App No: CM/13/18/OUT

Address: Land to West of Church Lane South of Horsemere Green Lane Clymping

Proposal: Outline application with some matters reserved for the erection of up to 300 dwellings and ancillary development comprising open space, a building within use class D1 of up to 875 square metres net, a building for A1 use having a floor area of up to 530 sq. metres net, together with open space and ancillary works, including access points, car parking and drainage arrangements, with appearance, landscaping, layout; and scale wholly reserved for subsequent approval. The access detail, showing the points of access to the development, and indicated on Bellamy Roberts drawings numbered 4724/013 and 4724/005 Rev A are access proposals to be determined at this stage of the application. For the avoidance of doubt all other access detail within the site is to be determined as a reserved matter at a later stage. Resubmission following CM/1/17/OUT. Departure from the Development Plan.

Environment Officer
Environment
Chichester District Council

Figure 1: Land at Church Lane Habitat Survey Map

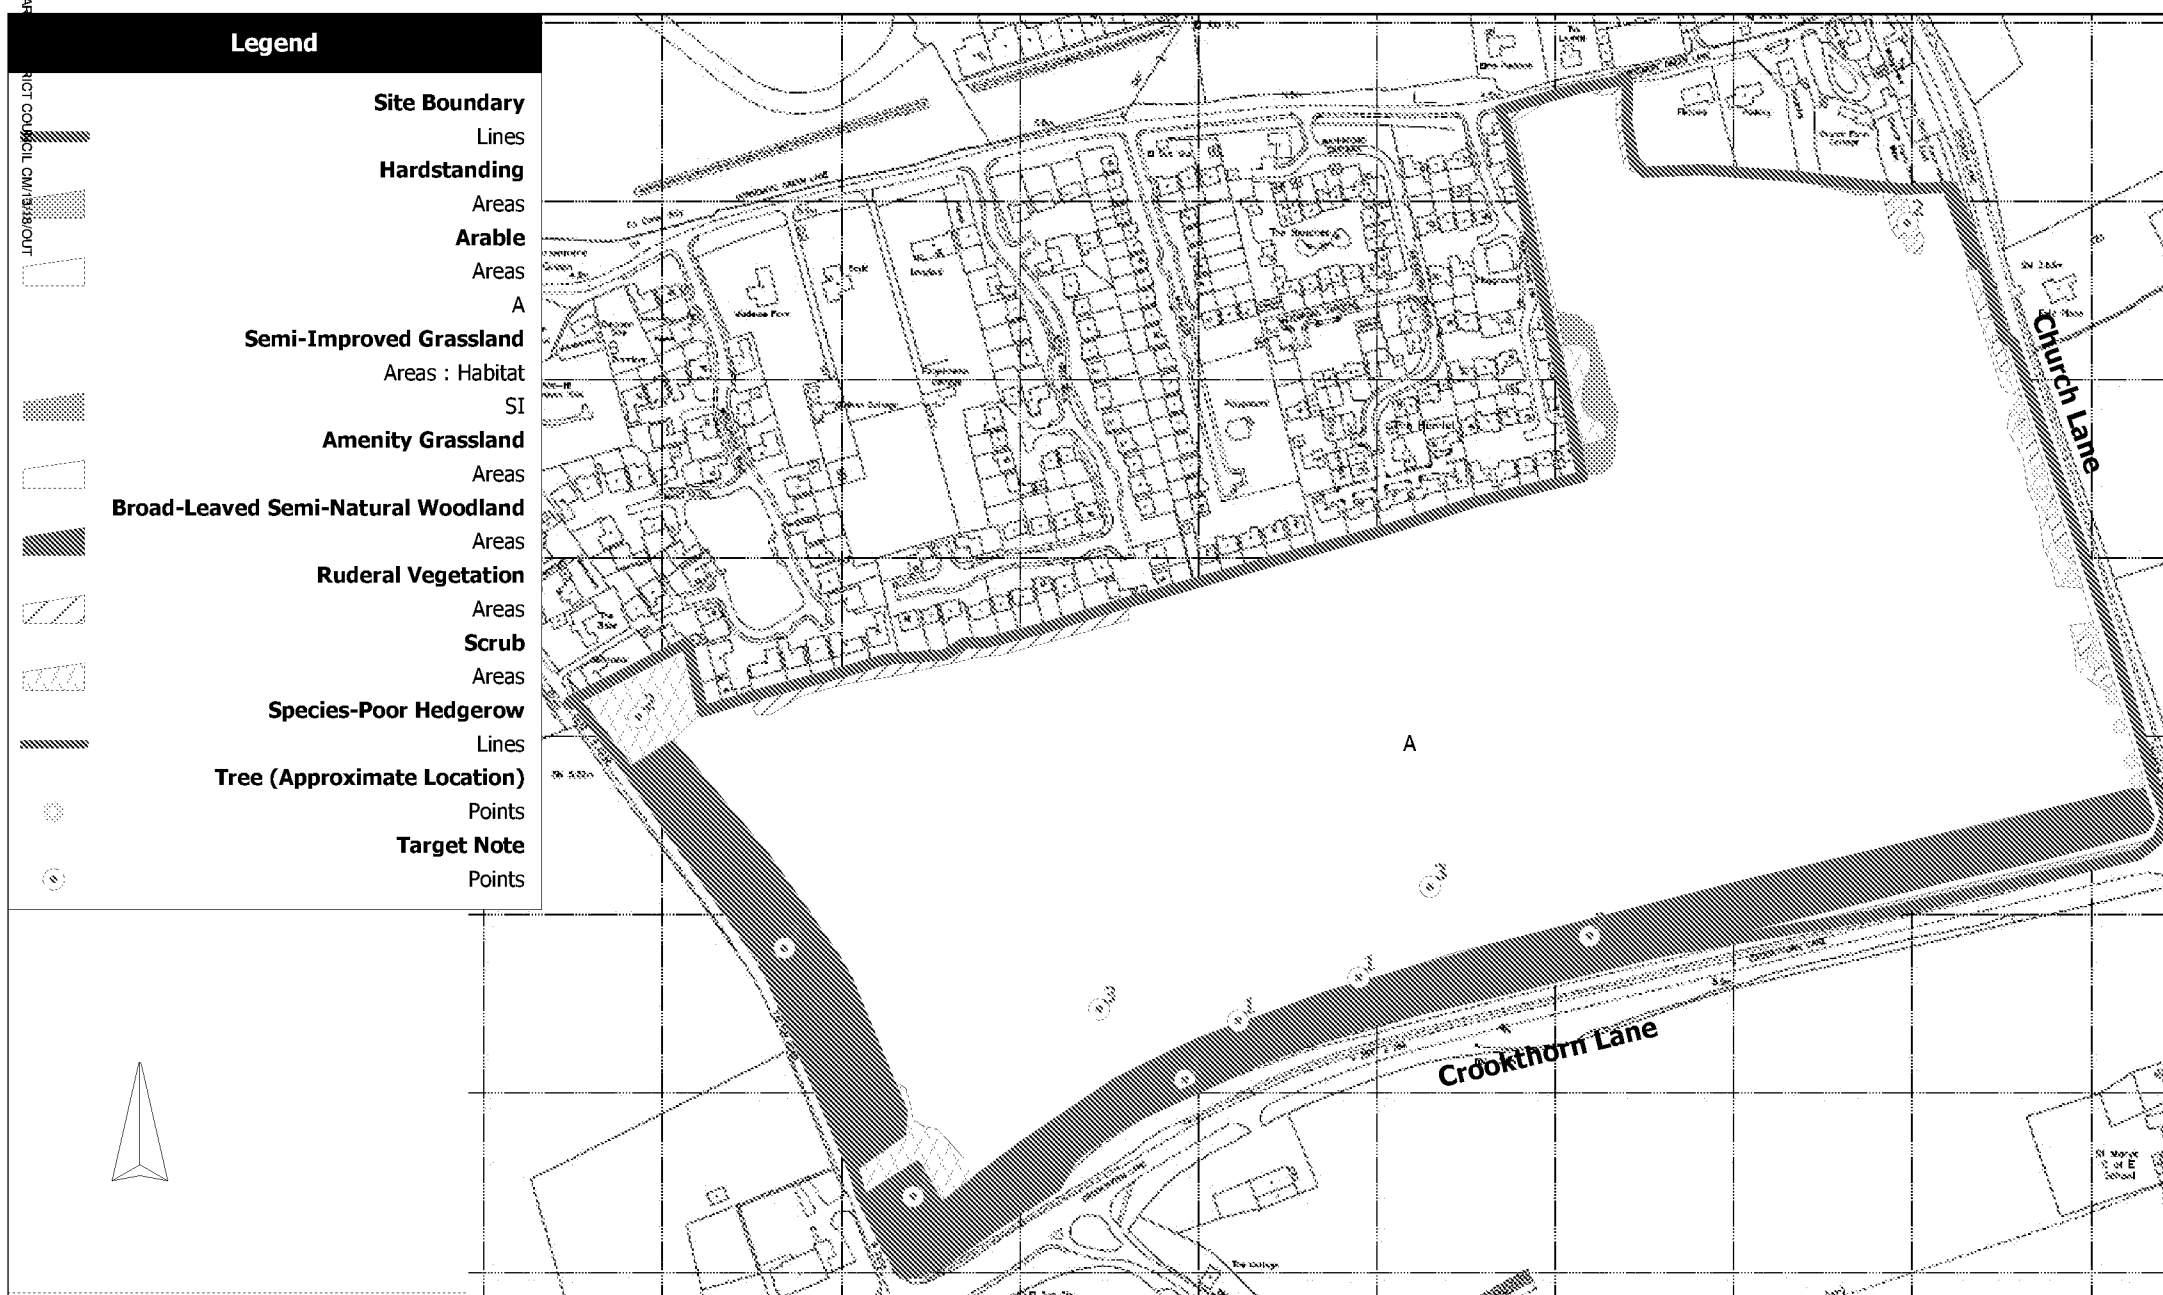
These areas should be retained and any gaps which need to be created within the tree lines and hedgerows should be kept to a minimum. Where gaps have to be made, enhancements should be made to reduce the impact on the tree / hedge line for commuting and foraging bats. This could be done through directional lighting away from the vegetation and using the surrounding trees to create a continuous canopy over the road.

The mature trees and hedgerows should be retained as part of the proposals and the areas should be enhanced with new tree lines and hedgerows. This includes the southern and western boundaries of the site. Currently none of

the trees which have been identified as having bat roosting potential are due to be removed. However if this changes then bat emergence surveys will be required on these trees
